Ribble Valley Borough Council

App no: 3.2026.0230

Address: Land to the south of Ribblesdale Primary School west and north of Higher Standen Drive, Clitheroe

Proposal: The erection of 60 dwellings comprising houses, bungalows, flats, related infrastructure (including public open space) and landscaping.

Drawing No.	25-166-P01	Rev.	A
Scale:	1:500		
Date:	Jan 26		
Sheet Size:	A1

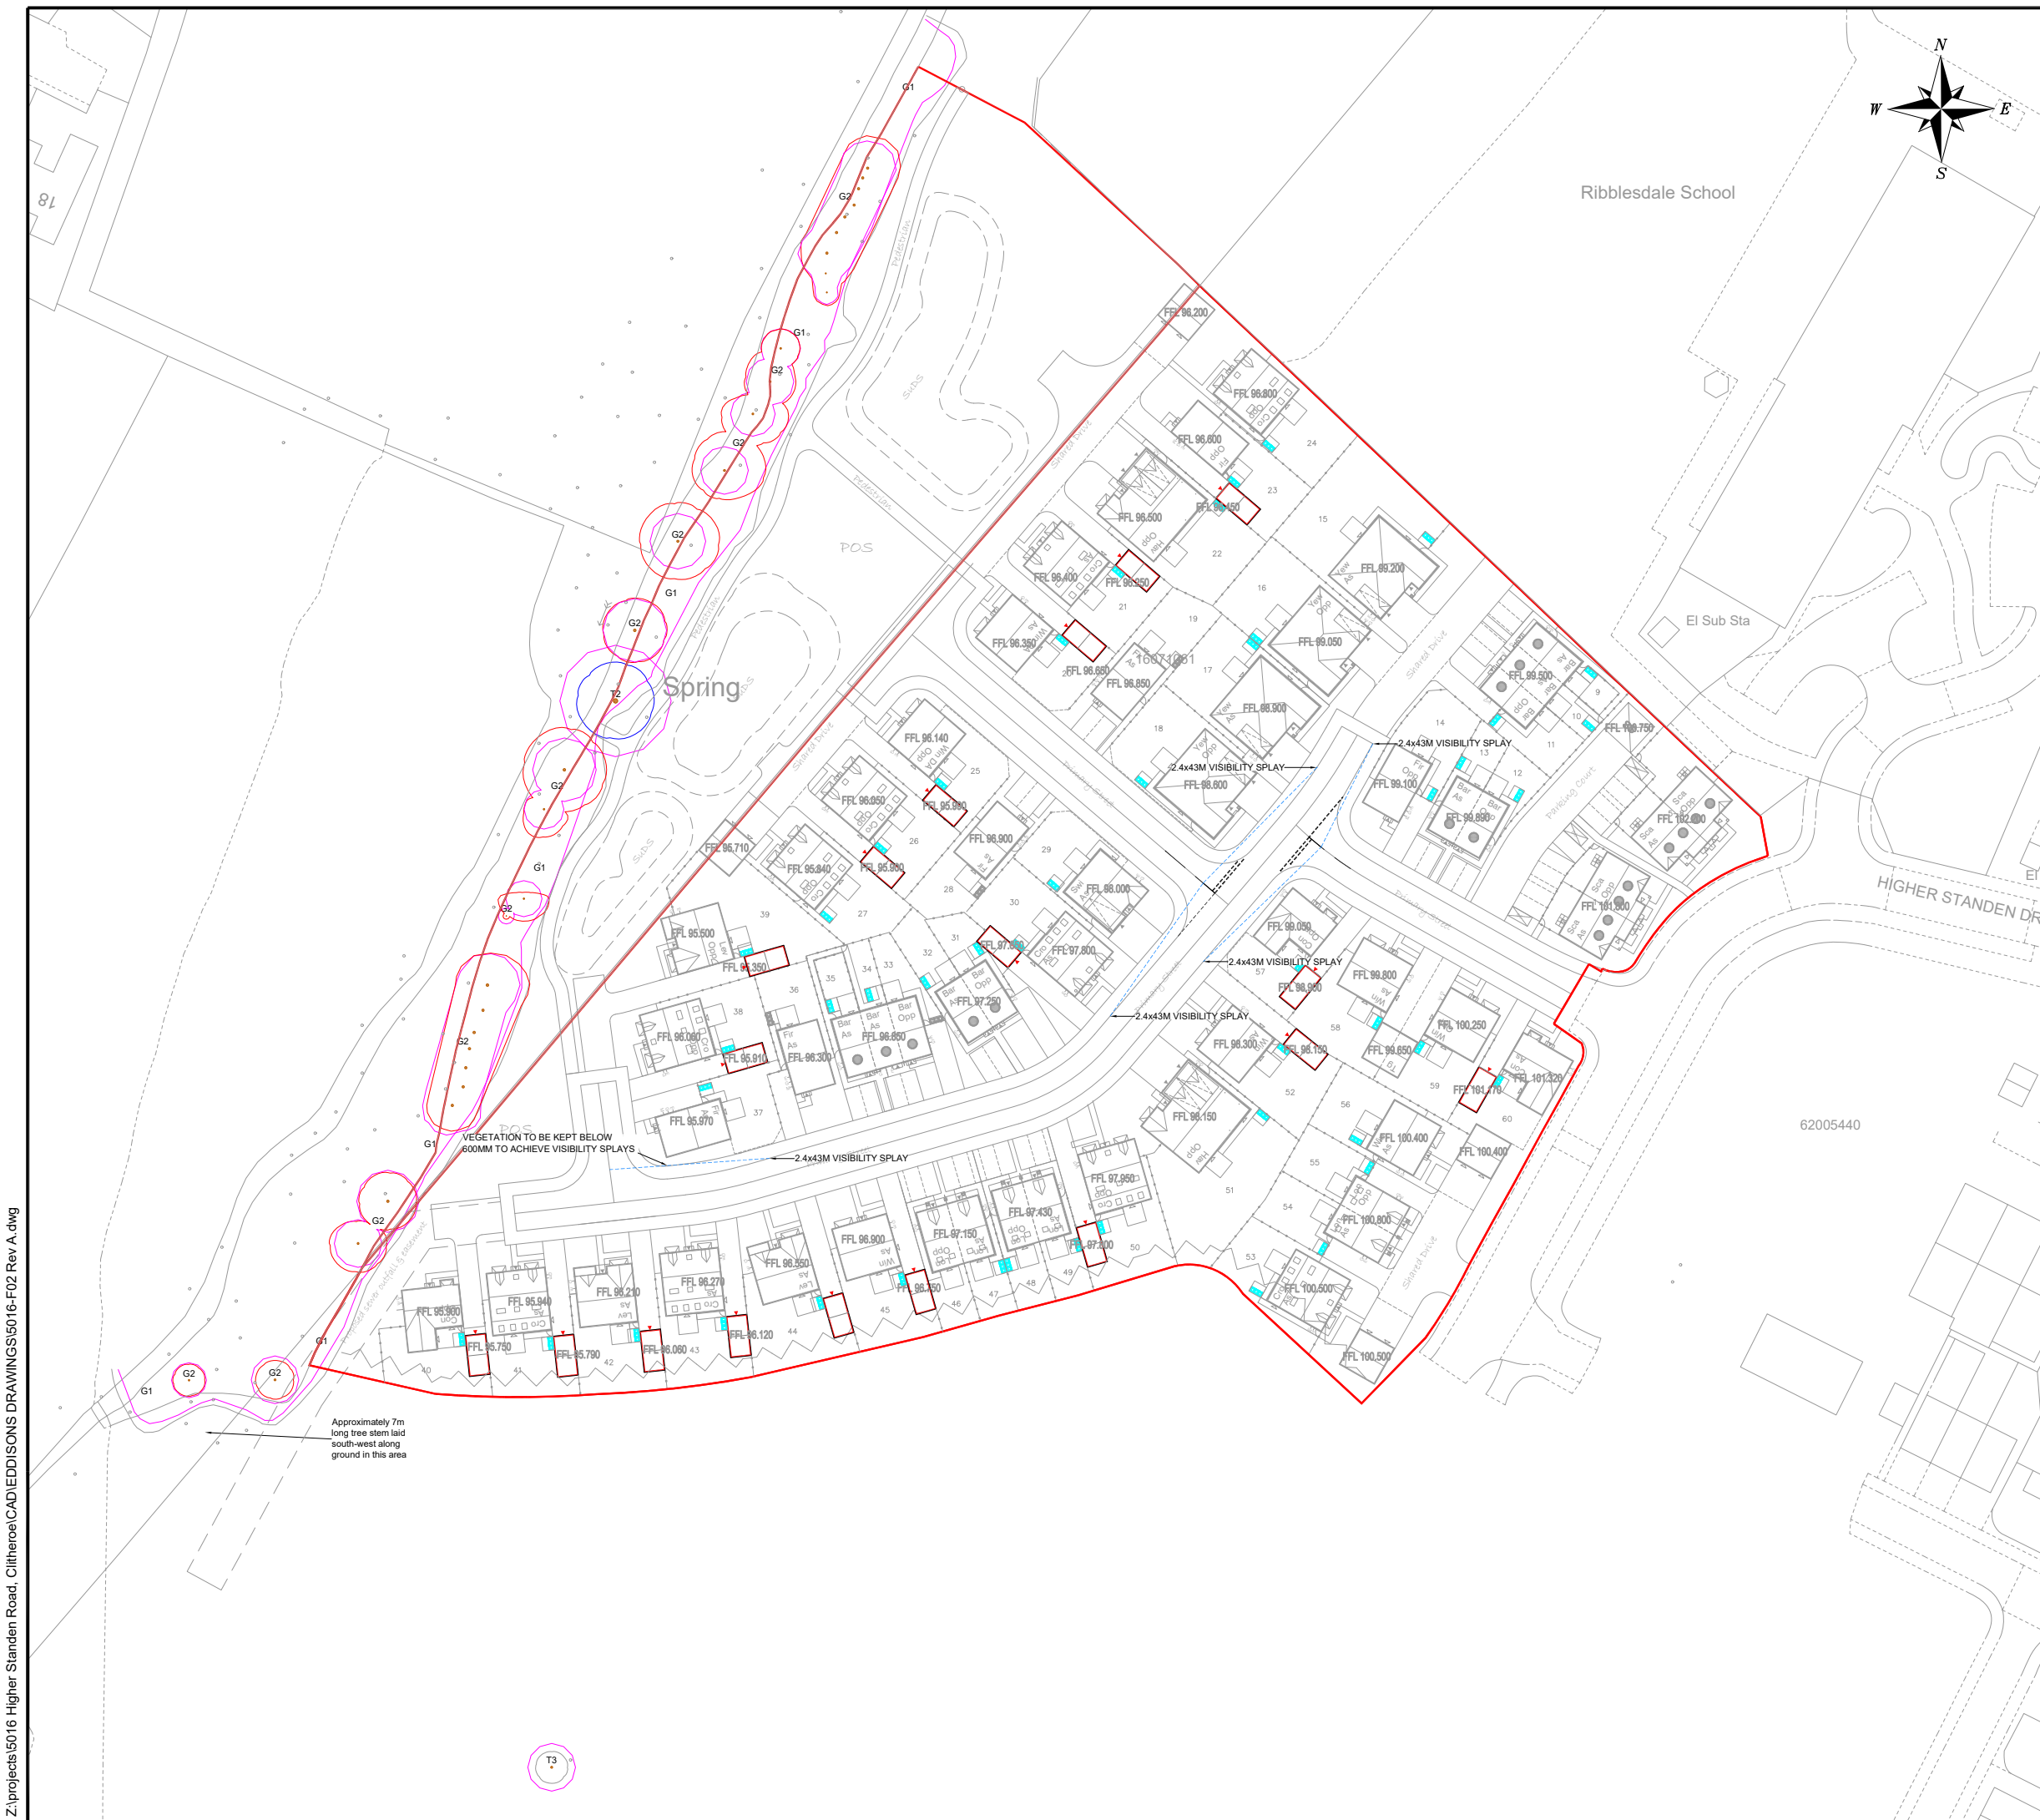
Potential pedestrian links are indicated on the internal layout on the northern and western boundaries. This ties in with the existing walked desire lines evident on site shown below in orange on the extract map.

There should be a pedestrian/cycle connection to the southwest corner of the site near plot 40.

We would request that Phase 5/6 proposed plot layout (application 3.2022.0317) is included on the layout to show how links tie into the adjoining development.

Each plot has a driveway for 1 or 2 cars and certain larger plots have a garage measuring 3m by 6m internally. Each plot without a garage must have a secure and covered cycle store for at least 2 bicycles.

DRAWING NUMBER: 5016-SP01	REVISION: B
-------------------------------------	-----------------------

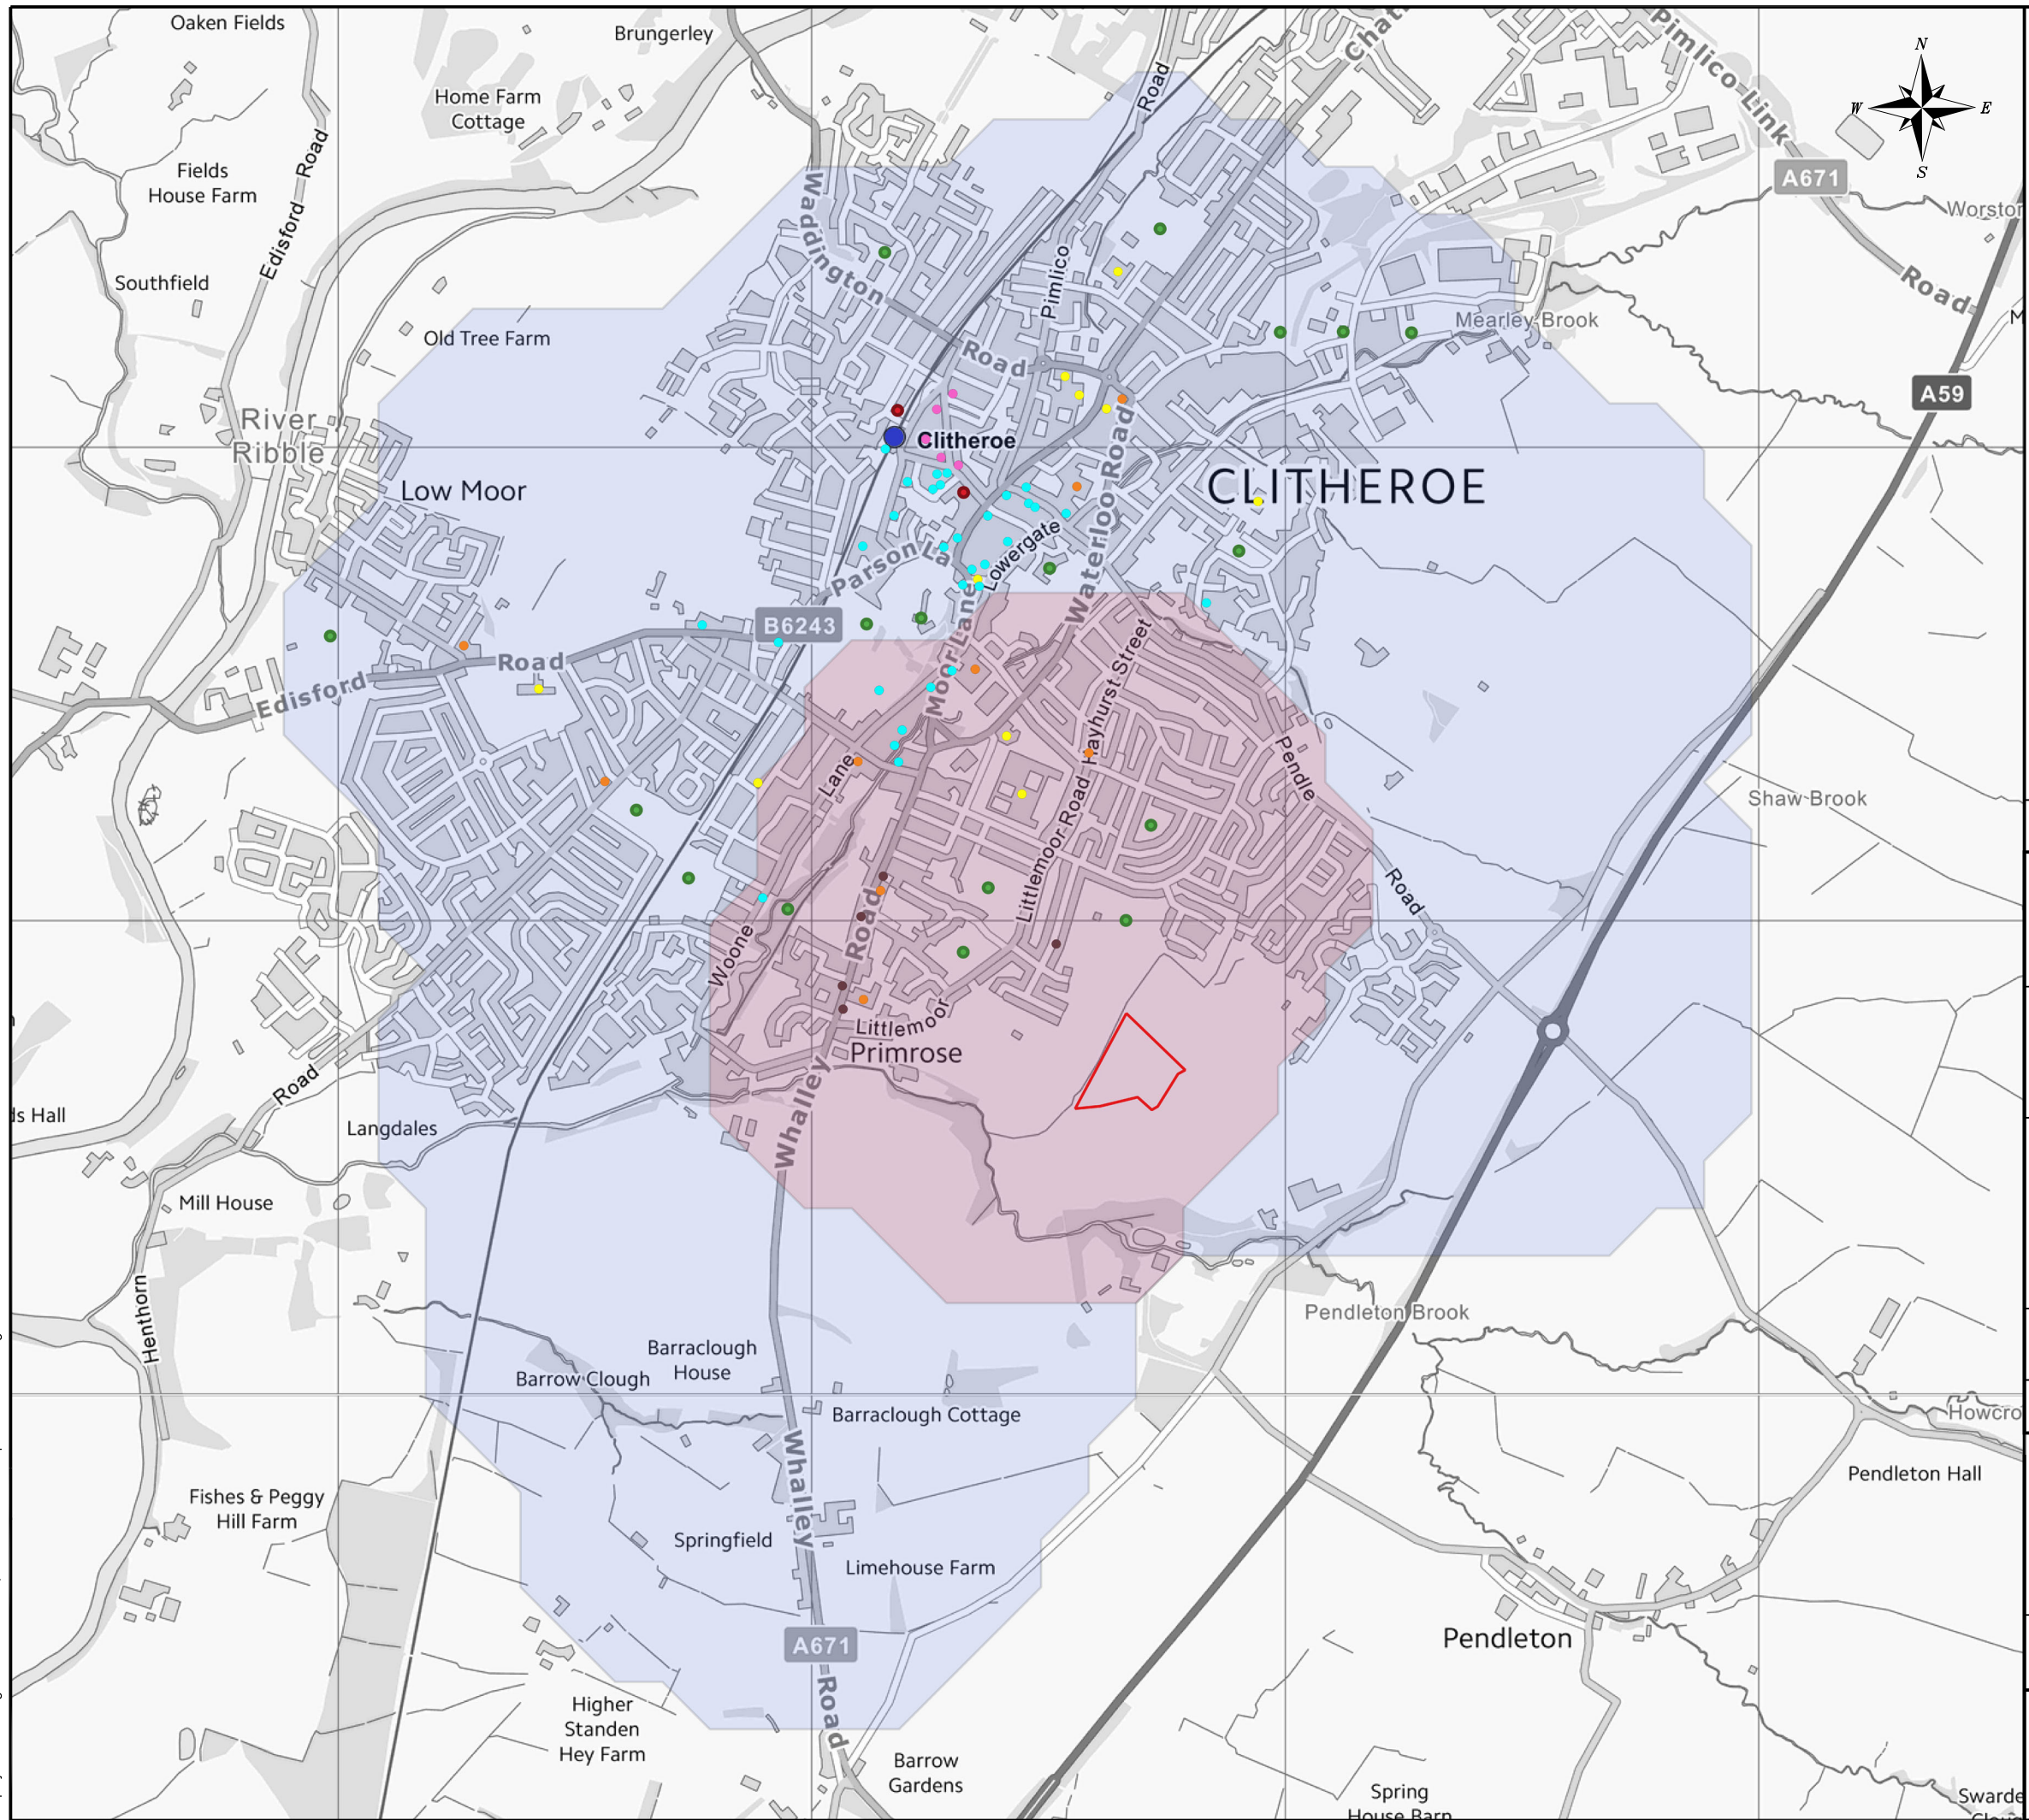
The visibility splays have not been updated as previously requested however we consider that this can be conditioned.

Visibility splays of 2.4m by 25m to both sides are shown on a drawing in the Transport Statement, the splays will lie in land proposed to be highway.

The splays need to be extended to 2.4m by 43m to both sides as Higher Standen Drive is anticipated to be subject to a 30mph speed limit.

There is a private driveway proposed onto the spine road to serve plots 53-56. Splays for this site access are required to be submitted at 2.4m by 43m.

(a) Site access to include visibility splays of 2.4m by 43m to both sides along Higher Standen Drive.

(b) Pursue traffic regulation order (double yellow lines) at site access junction Higher Standen Drive.
